Statement of Response to ABP's Opinion

**Proposed Development at Concorde Industrial Estate, Naas
Road, Dublin 12**

John Spain Associates

May 2019

1 Section K1 Future Naas Road Longitudinal Section  
1 : 200

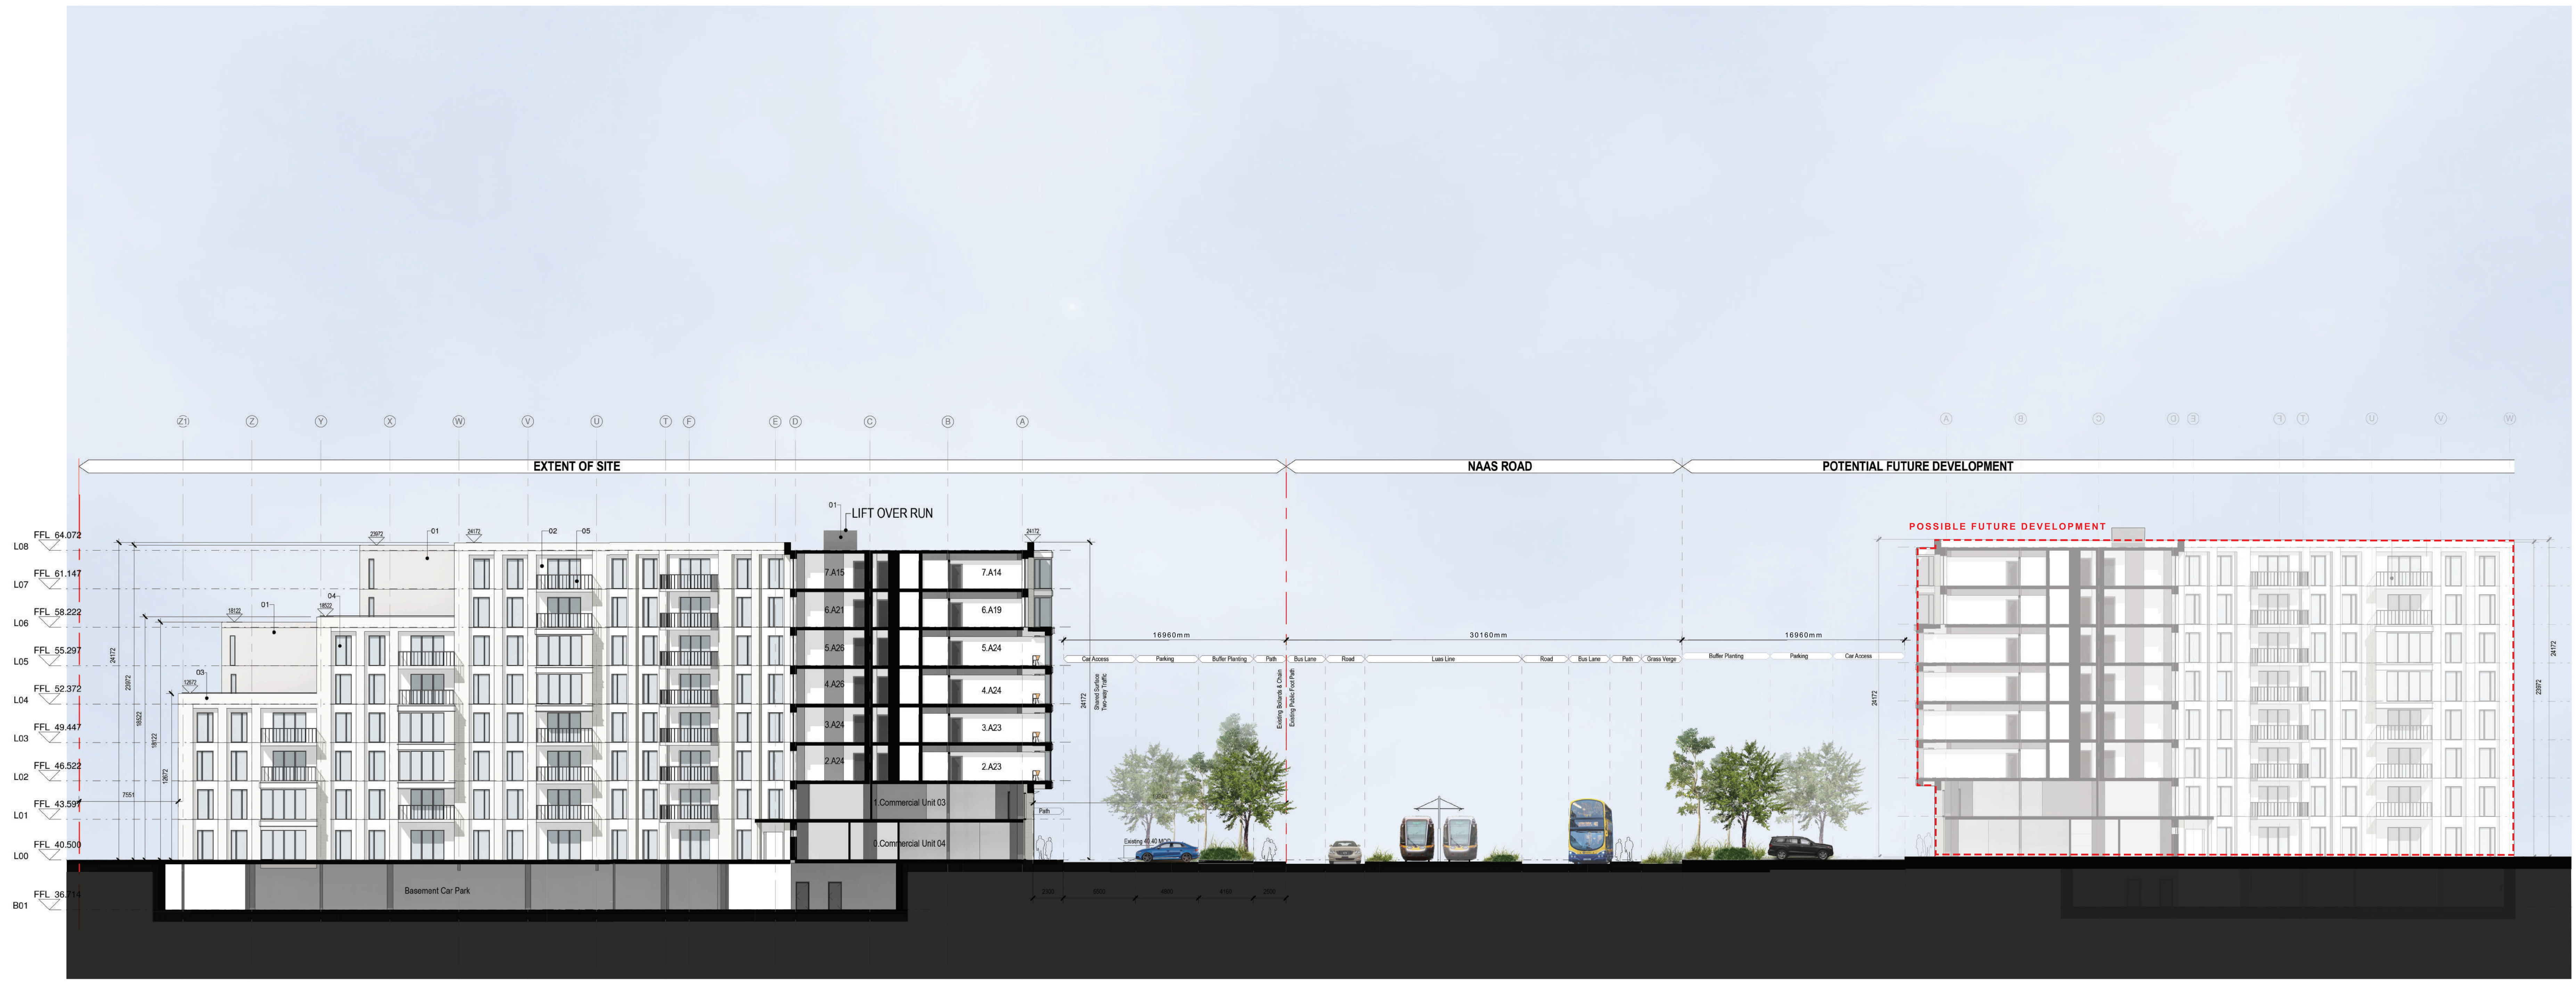
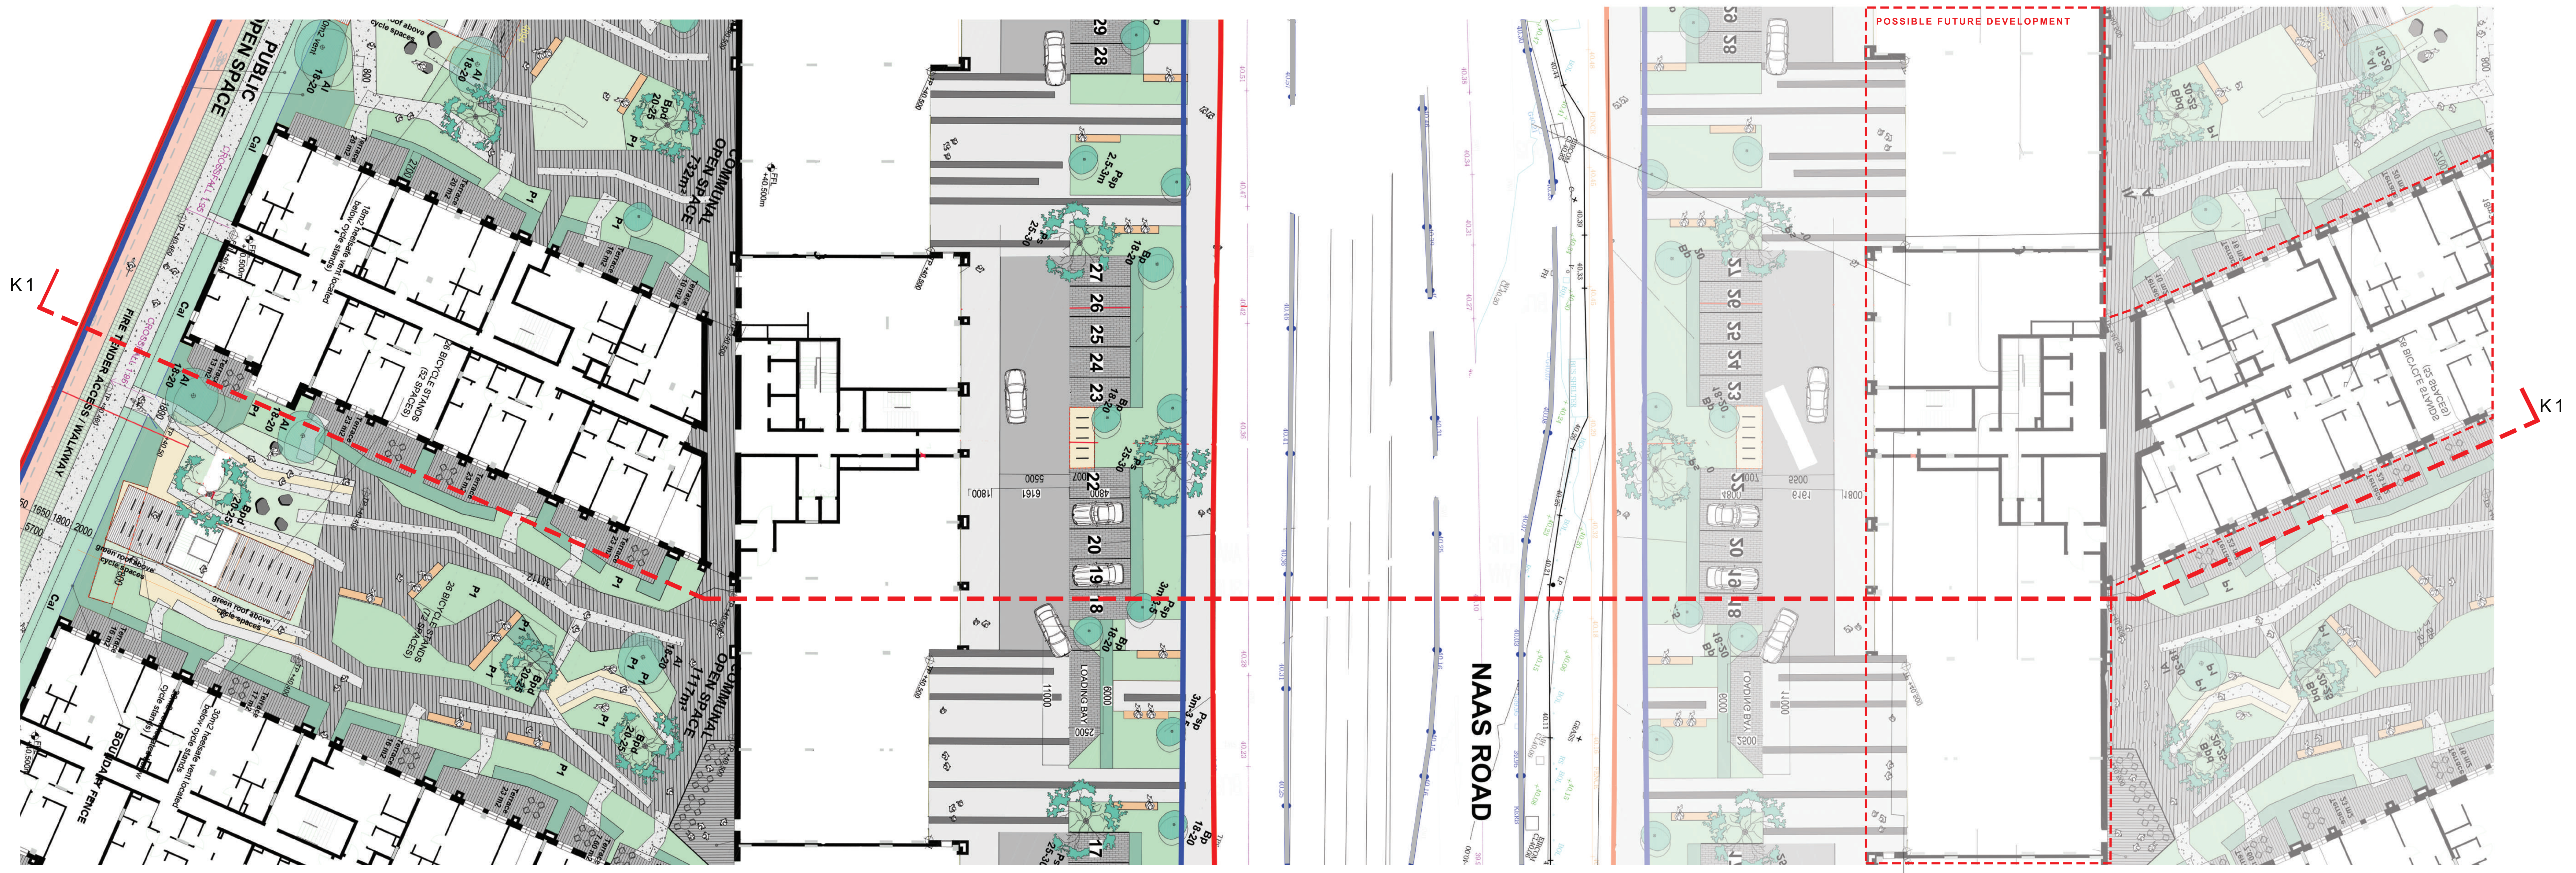
- Cross sectional drawings showing the proposed development in the context of full width of the Naas Road and the buildings on the other side.
 - Proposals for the management and operation of the proposed development as a "Build to Rent" in accordance with Specific Planning Policy Requirement No. 7 of the 2018 Guidelines on Design Standards for New Apartments, including detailed proposals for the provision and management of support facilities, services and amenities for residents. A building life Cycle Report in accordance with section 6.13 of the guidelines should also be submitted which specified the use of low maintenance and durable finishes, possible in substitution for the render panels shown on the submitted elevations.

- 3.1 The following sets out how the applicant has addressed the Board’s request for additional specific information in respect of the proposed development pursuant to article 285(5)(b) of the 2017 Regulations.
- *Item No.1 – Cross sectional drawings showing the proposed development in the context of full width of the Naas Road and the buildings on the other side.*

- 3.2 The subject application is accompanied by a cross sectional drawing of the Naas Road interface which highlights the appropriateness of the building height, scale and mass in accordance with the existing and future development potential of the area and the dominance of the Naas Road.
